Suffolk County Council (20041323)

**Revised Annex F of the Suffolk Joint LIR
(Review of Site Accesses)**

Bramford to Twinstead (EN020002)

9 February 2024

Drawing title: **AB-AP5
Proposed Visibility Splay
Concept Design
Sheet 1 of 1**

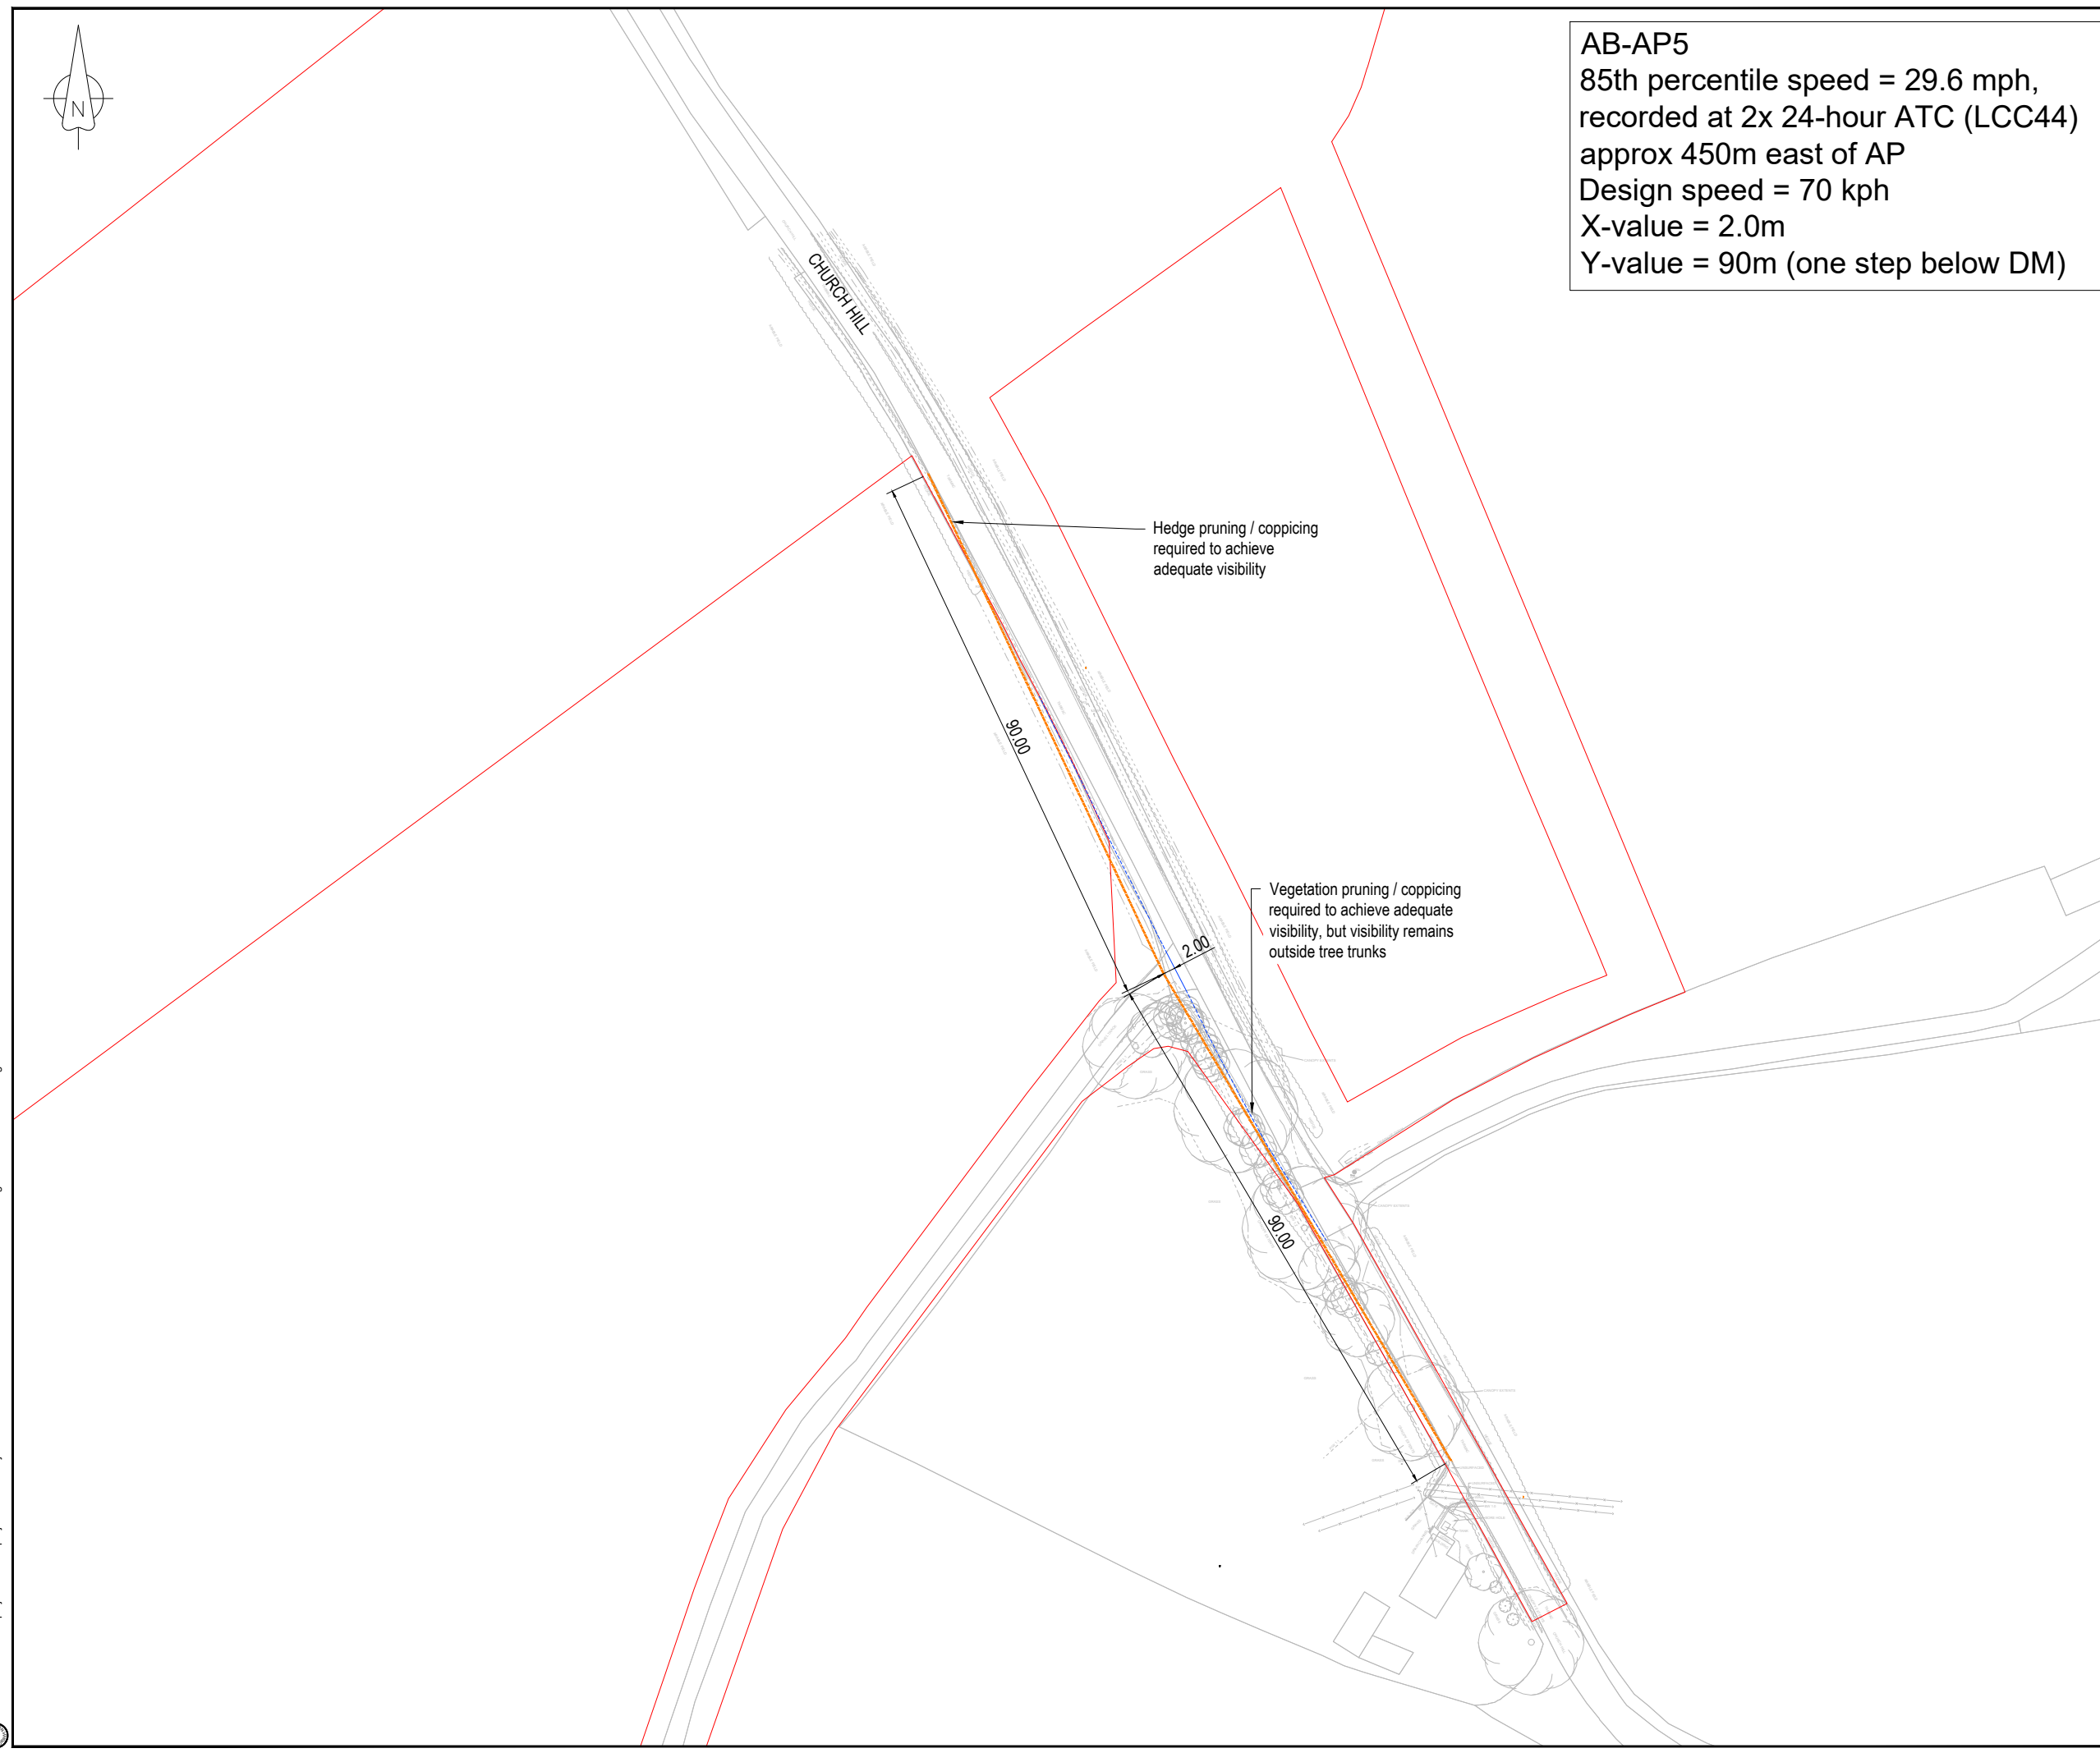
AB-AP4					new	4.4	60	n/a	215	no	yes	Temporary	166	0	292							LCC44 in centre of village / 30mph limit	
AB-AP5					field	3.2	60	n/a	215	no	yes	Temporary	172	0	398							Trees to south	
AB-AP2B	Burstall Hill				private	5.4	60	n/a	215	no	yes	Temporary	236	12	168						Private access, kerbed but over-run		
AB-AP6	Back Road (not Ipswich Road)	Hintlesham	A1071	Sheet 3	private	5.4	40	n/a	120	no	yes?	Temporary	684	0	1566		30mph	90m	2x90m	none	n/a	7am-7pm	Trees may require trimming. On sharp bend. Secondary access to Hintlesham Hall
AB-AP7					field	5.7	40	n/a	120	no	no	Temporary	674	0	1212								
AB-EAP1					private	5.4	40	n/a	120	no	yes	Temporary	0	0	0								On bend
AB-AP8				new	6.0	40	n/a	120	no	no	Temporary	1536	0	1396									
AB-EAP2a	Ipswich Road	Hadleigh		Sheets 6	private	7.6	60	n/a	215	no	no	Temporary	0	0	0								
AB-EAP2b					new	7.1	60	n/a	215	no	no	Temporary	0	0	0						May be an access off layby

F-AP10
 85th percentile speed = 31.5 mph,
 recorded at 2x 24-hour ATCs east and
 west of AP
 Design speed = 50 kph
 X-value = 2.0m
 Y-value = 70m (desirable minimum)

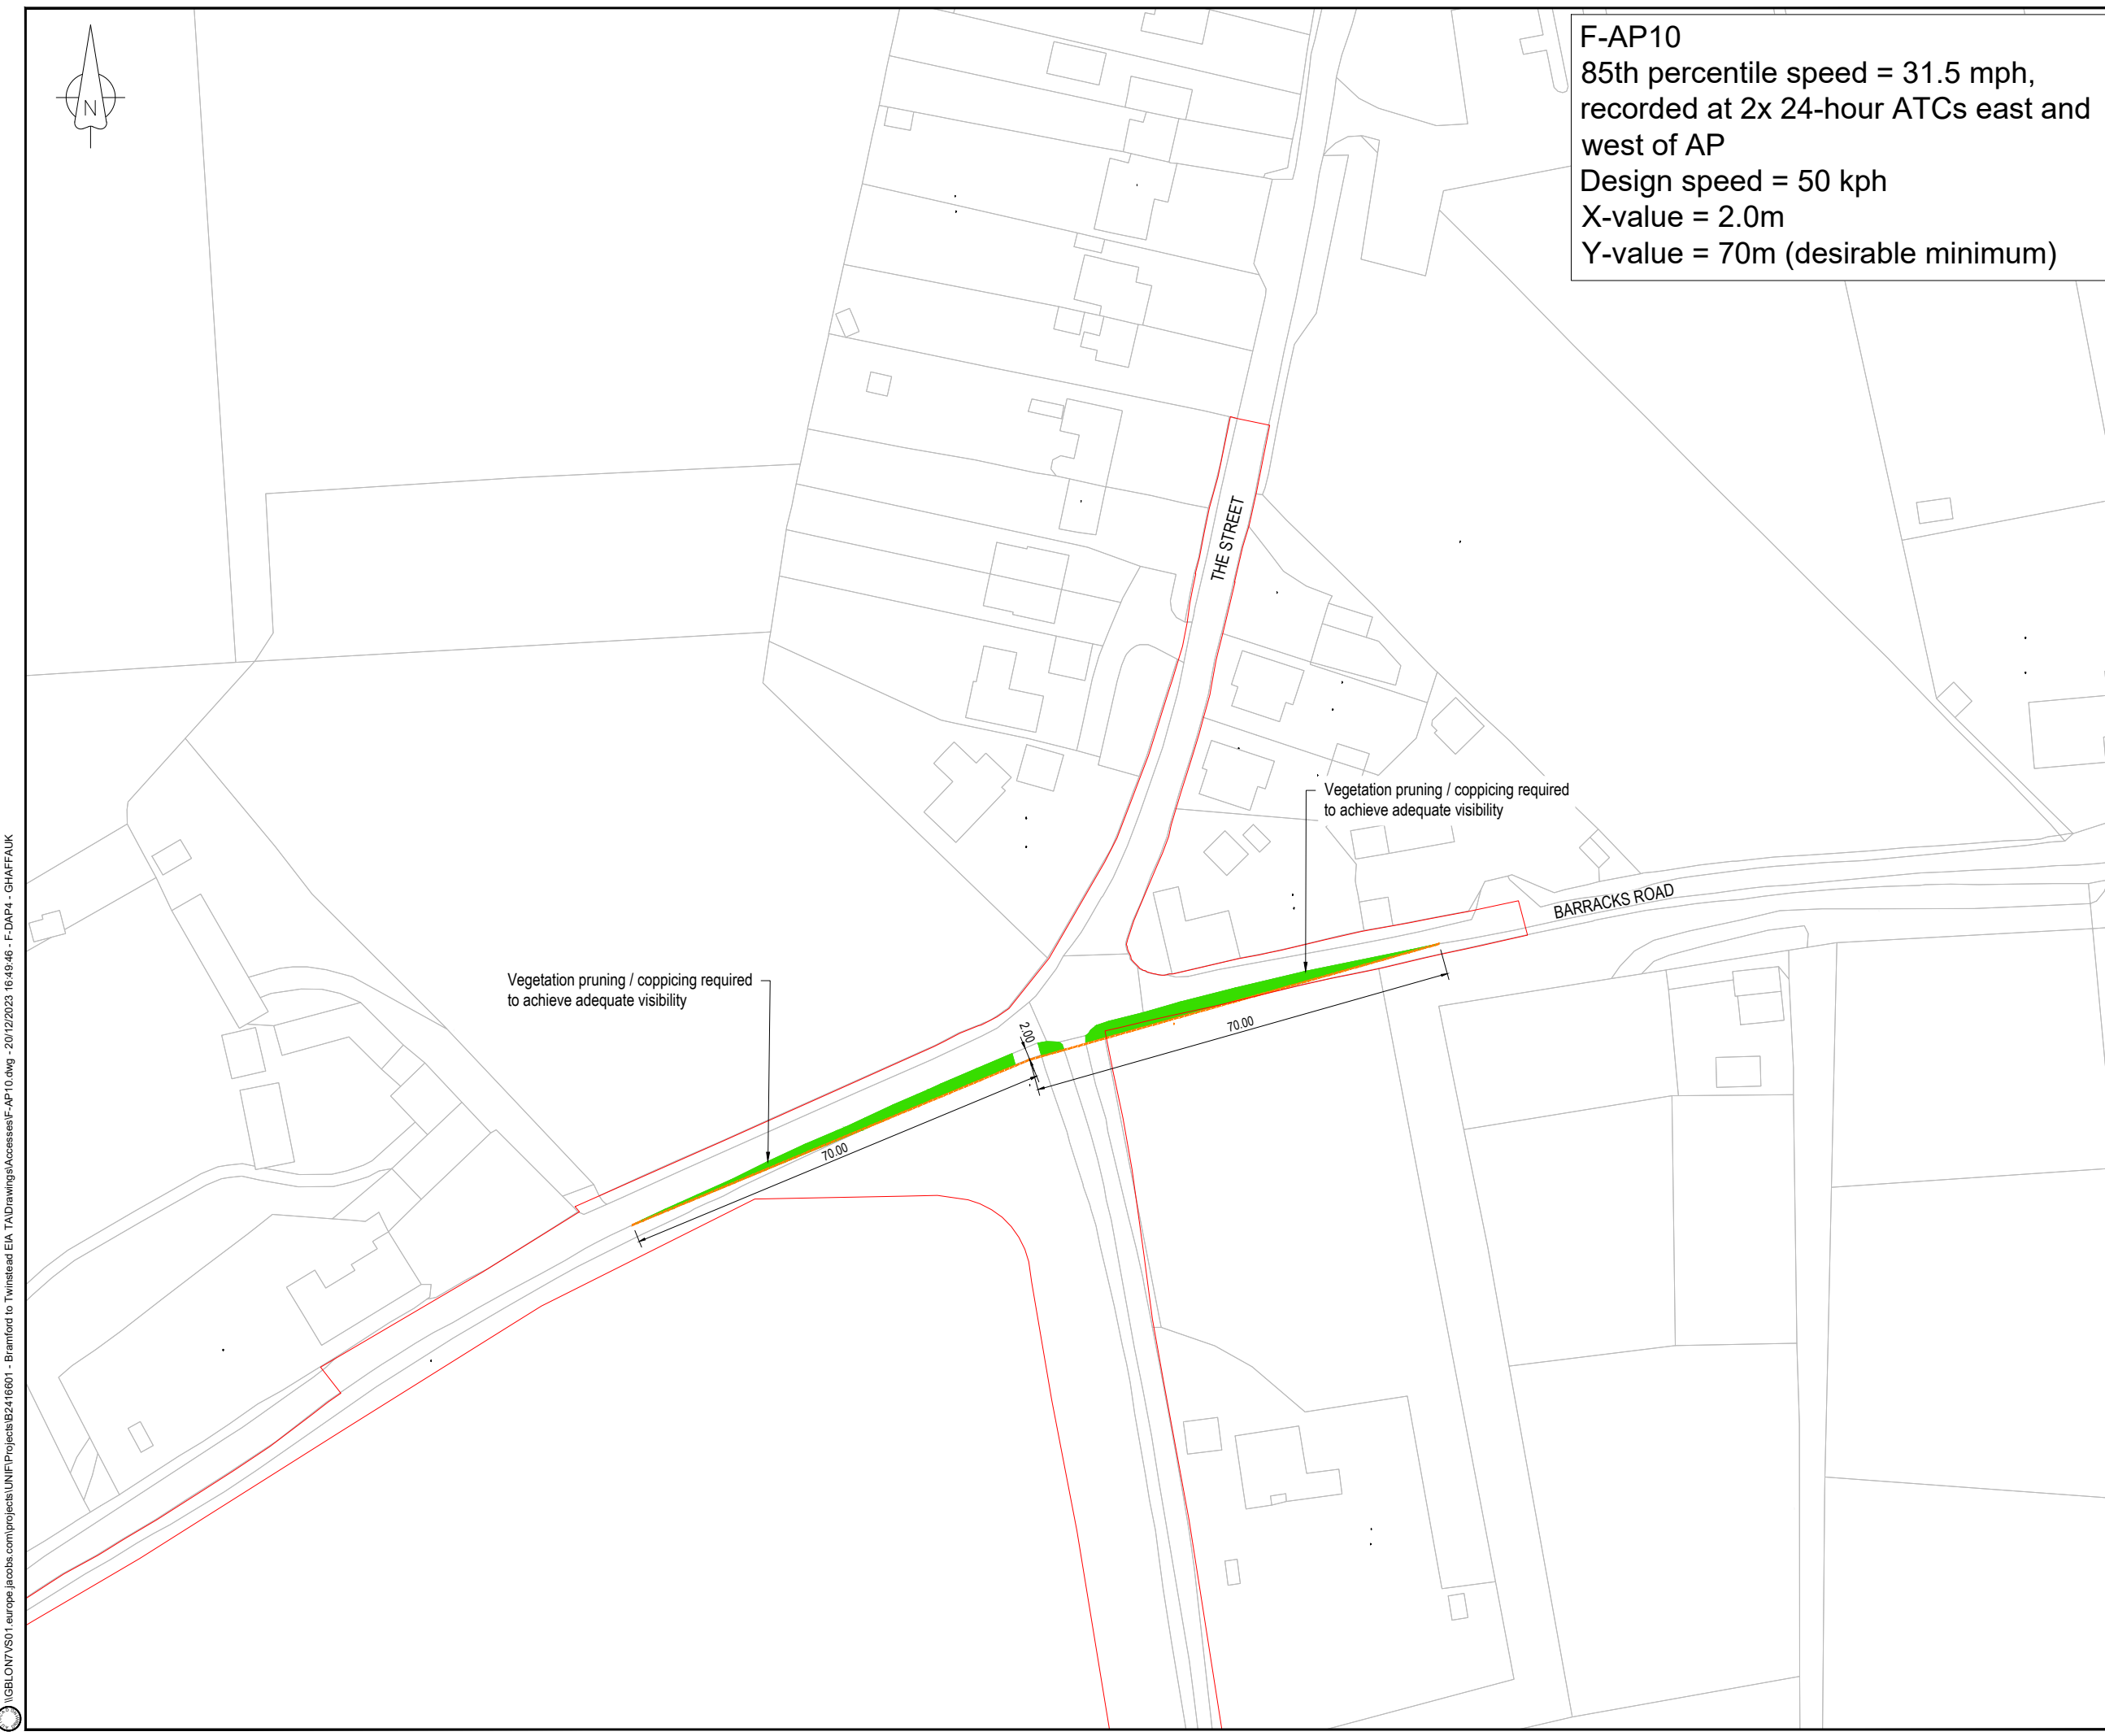
F-AP10	Bures Road (not Rose Green)	Assington	C733	Sheet 17	private road	4.8	30	n/a	90	no	yes	Temporary	586	0	544	n/a	subject to 30 limit	90m	2x70m	LCC75	31	7am-7pm	Junction of The Street, Barracks Road and Bures Road.							
F-DAP4					new	3.7	30	n/a	90	no	no?	Temporary	328	0	454								Note 85%ile speed 28 / 35mph week 1 / 2							
F-AP12					track	4.4	60	n/a	215	no	yes	Temporary	48	0	20															
F-DAP5					new	4.1	60	n/a	215	no	yes	Temporary	320	0	434															
F-AP13	Wormingford Road (not Smallbridge Entry)	Assington	U8607		new	2.8	60	n/a	215	no	no	Temporary	60	0	32	n/a	30mph	90m		Not available	n/a	7am-7pm								
F-AP14					field	3.9	60	n/a	215	no	yes	Temporary	464	0	562								n/a	30mph	90m		LCC17	34	7am-7pm	
G-AP2					field						yes	Temporary	456	0	992															
G-AP1	hardstand	4.6	60	n/a	215						no	no?	Temporary	696	0	1476														
G-AP3	St Edmunds Hill	Bures St Mary	B1508	Sheet 20	new	4.9	40	n/a	120	no	yes	Permanent	13400	0	4662	SO / STGO	30mph	90m		LCC15	45	7am-7pm	Poor compliance with speed limit Traffic calming necessary for temp speed limit
